Re: Immanuel Lutheran Church and School
300 Gold Avenue SE
Albuquerque, NM 87102
Comments Letter dated June 1, 2005

Please find response to your comments enumerated below:

SHEET TITLE:
GRADING & DRAINAGE PLAN

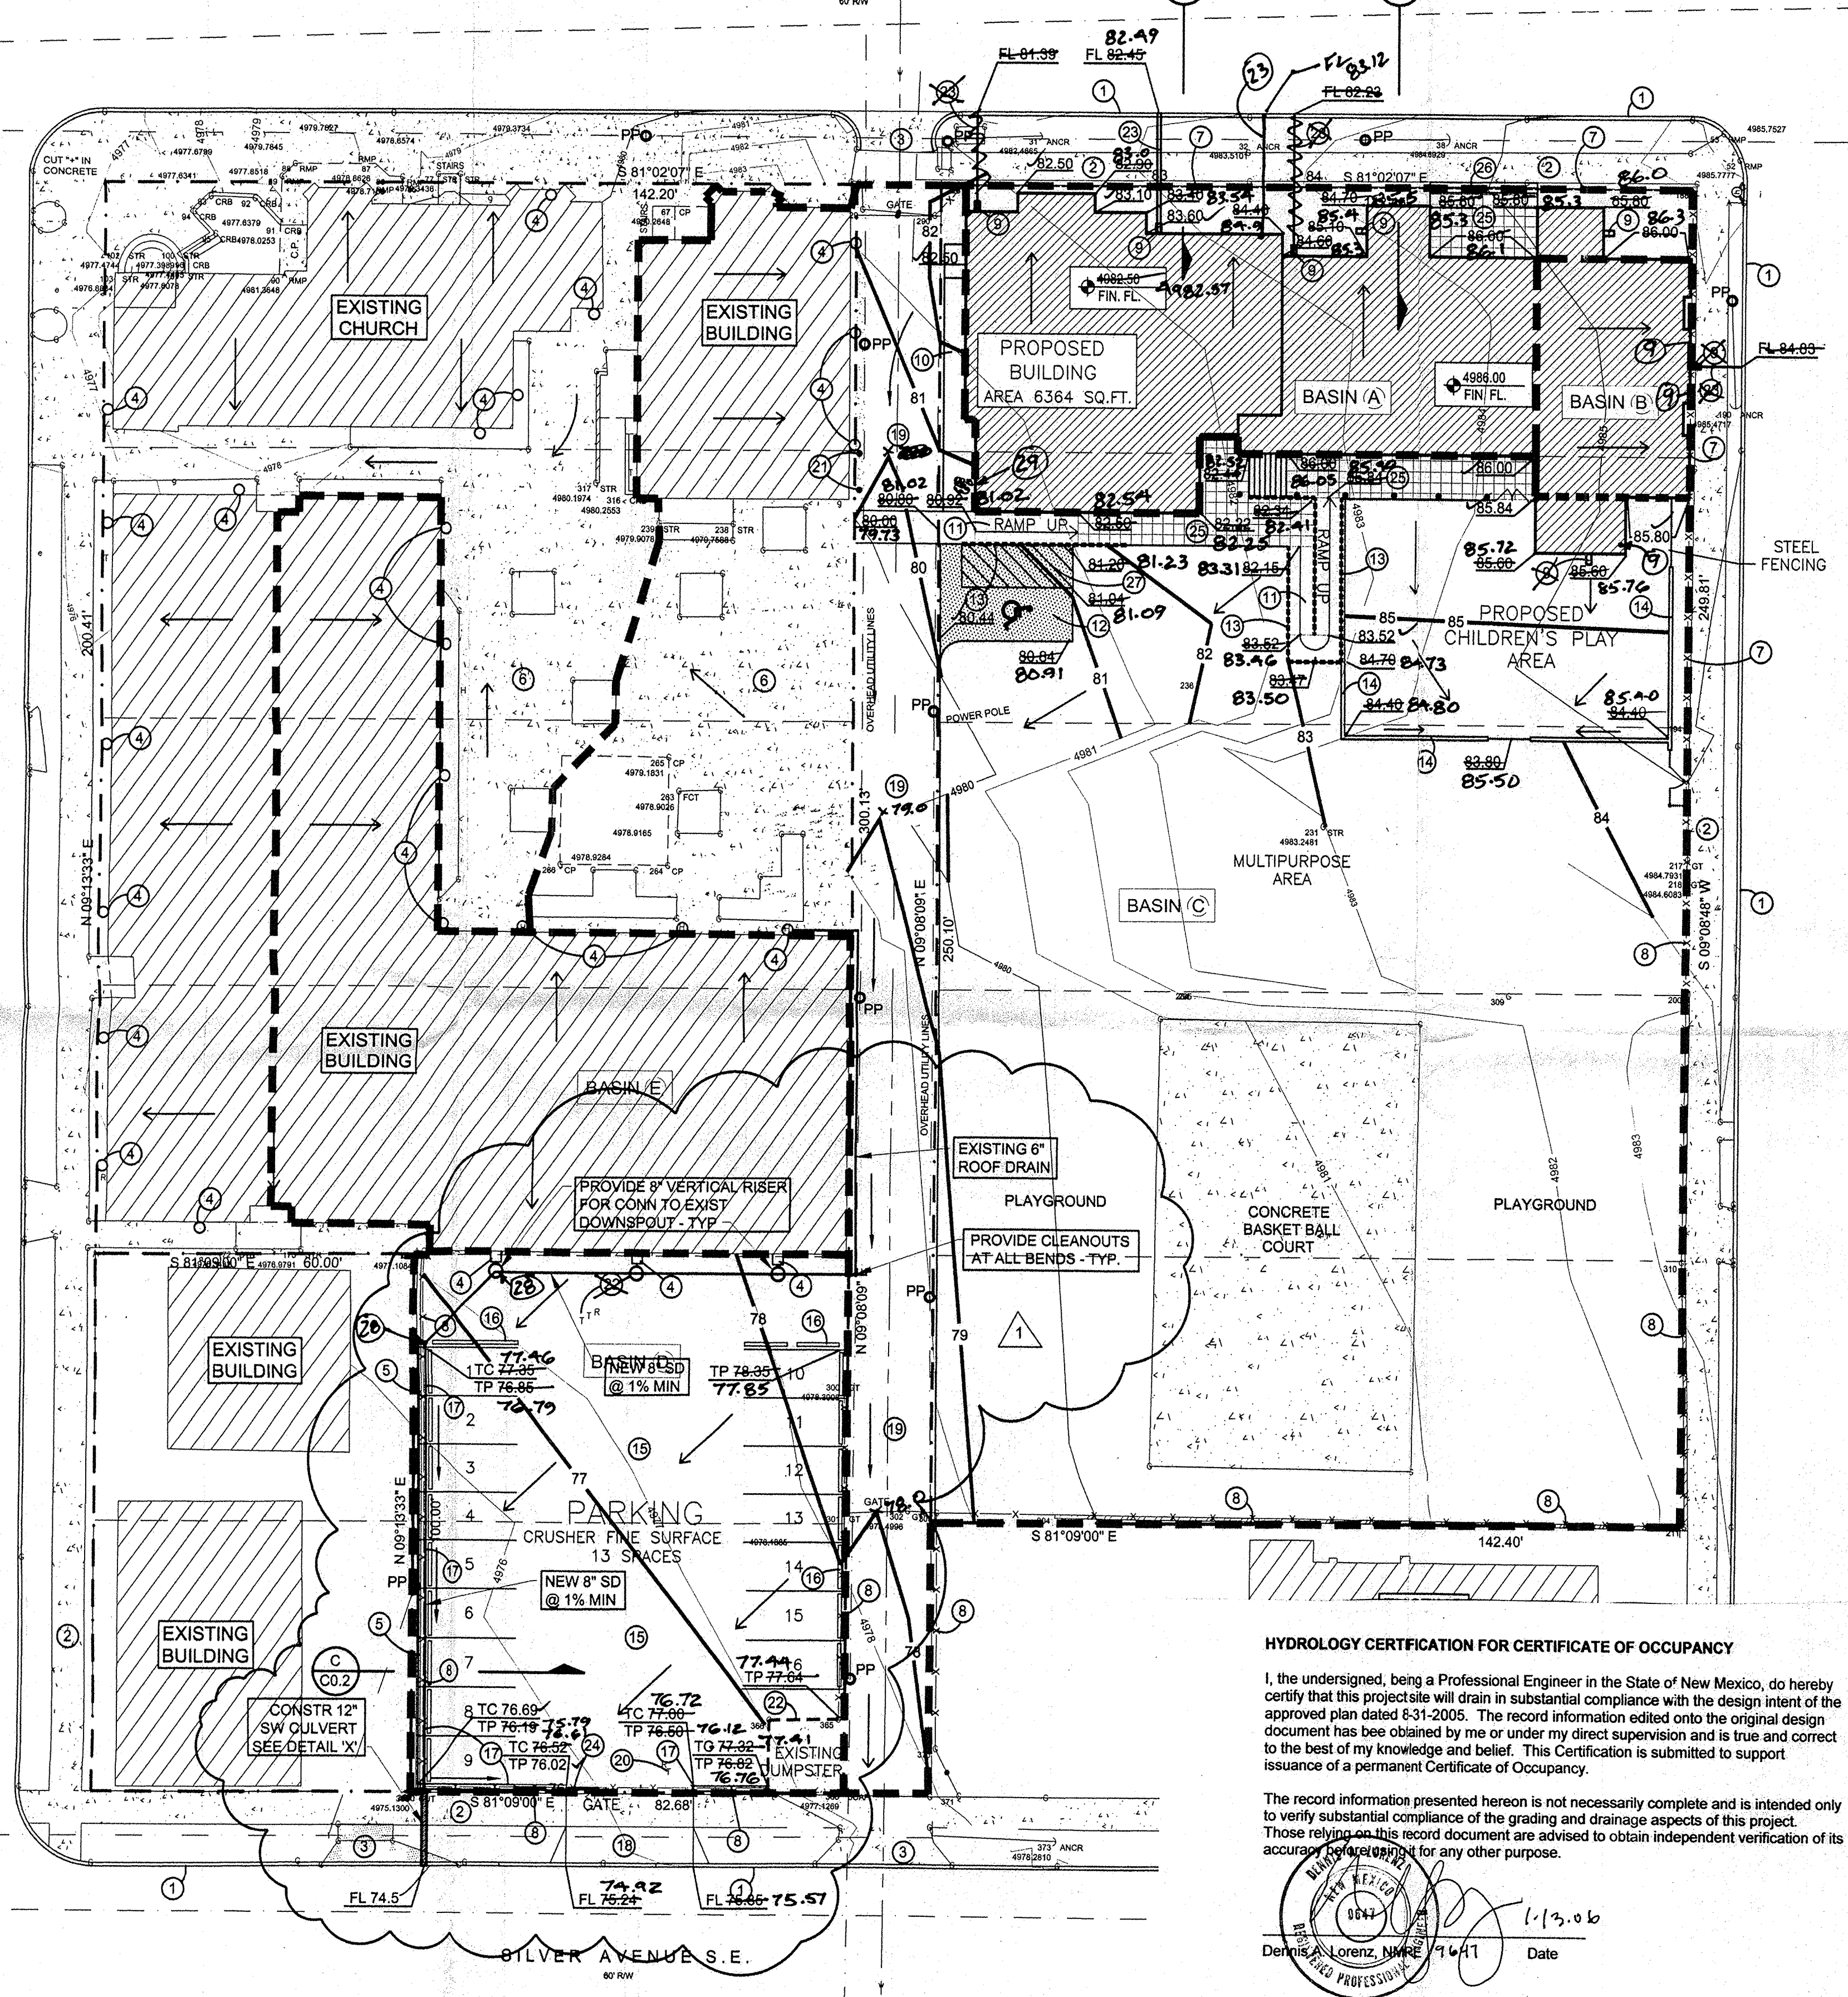
5. *Provide 24'-0" curb cut at Silver.*
See the revised TCL drawing showing revised curb cut dimension.
6. *Center new drive pad on 40' aisle.*
See the revised TCL drawing showing revised curb cut centered.
